CITY OF PORTLAND, MAINE  
MEMORANDUM

SUBJECT: Ashmont Street Subdivision

DATE: 3/17/88

ASHMONT STREET SUBDIVISION
 22-36 ASHMONT STREET, PORTLAND, MAINE
 FOR PETER L. BASS TO MERRILL ST. PORTLAND, MAINE

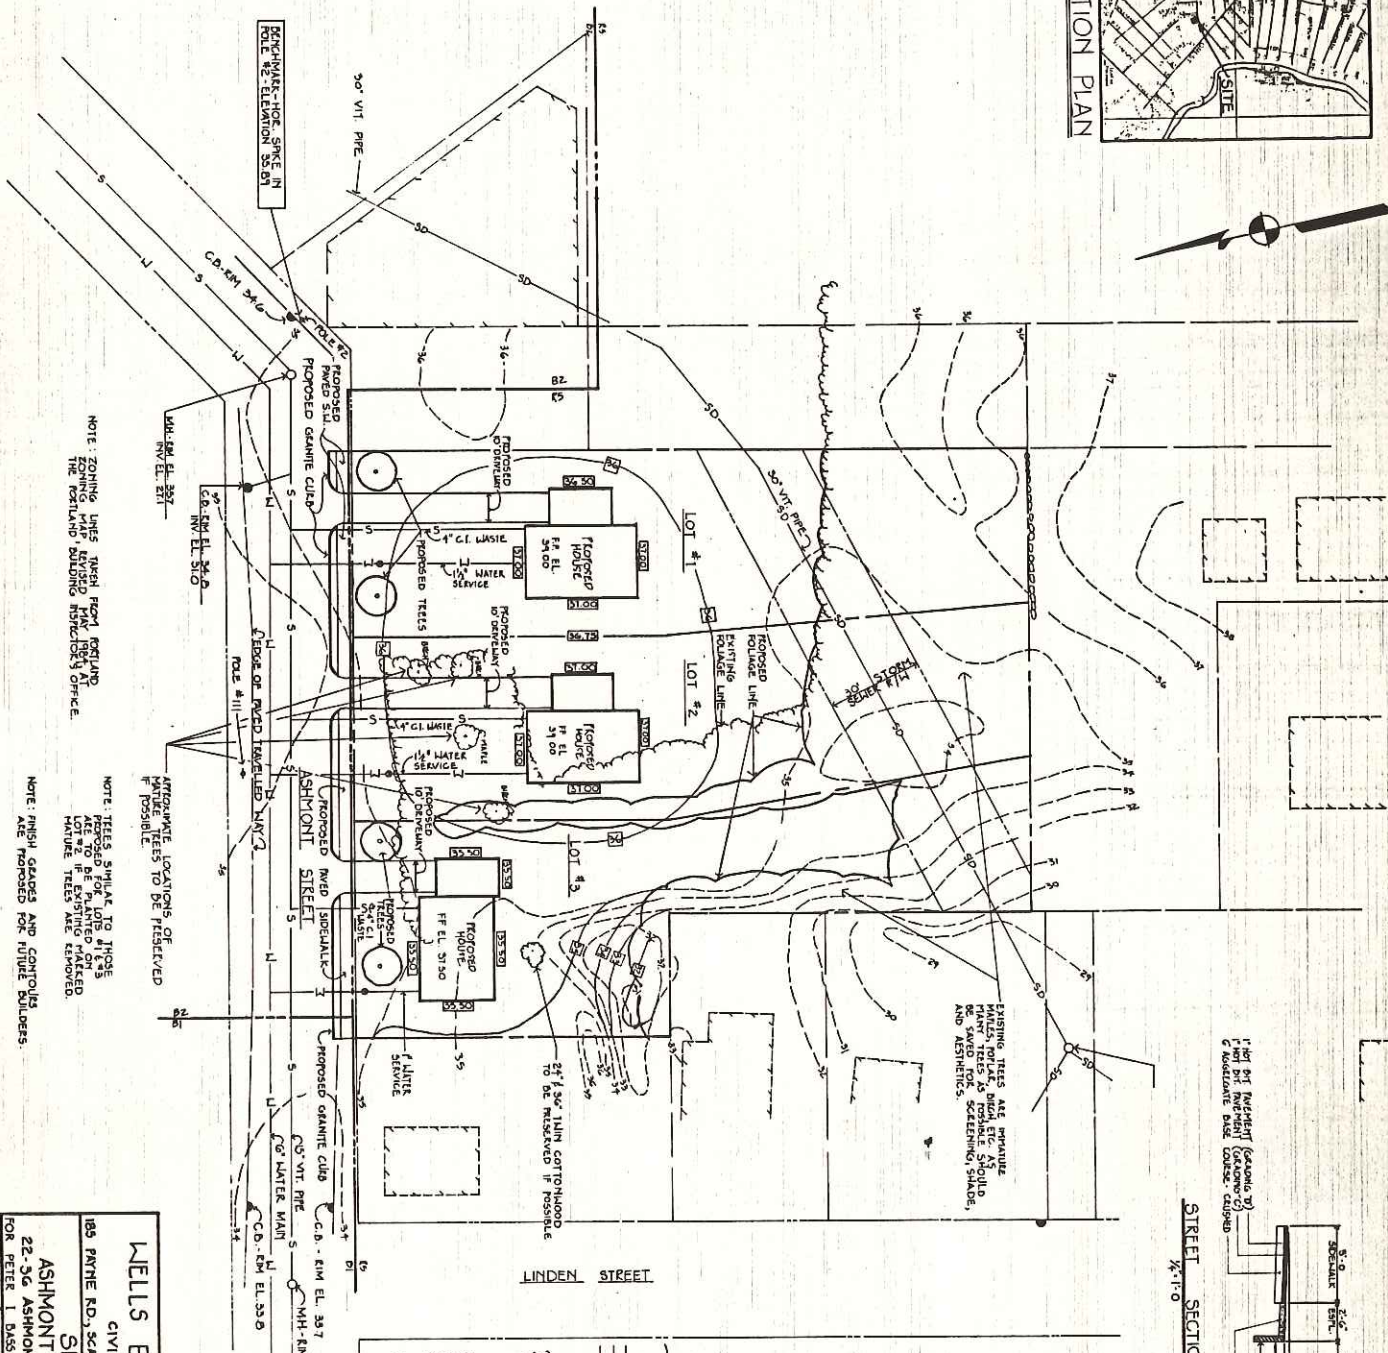
- 1) The subdivision (recording) plan should be based on a survey noted as done in accordance with state standards (with or without exceptions). The plan shall note irons to be set at all lot corners or angle points.
- 2) I am uncertain what the status is of the 30" storm drain which crosses the property. Assuming that the City is responsible for maintenance, the applicant should create a 30 foot wide storm drain easement, indicate it on the plan and convey the easement to the City.
- 3) According to the engineer's drainage plan, most of the site drains to a low area southerly of the Burrill property. Apparently, the drainage structure there is buried. This drainage inlet shall be returned to a functioning condition as part of the subdivision improvements.
- 4) I see no technical reason to waive the requirement for curb and sidewalk along the frontage of Ashmont Street.
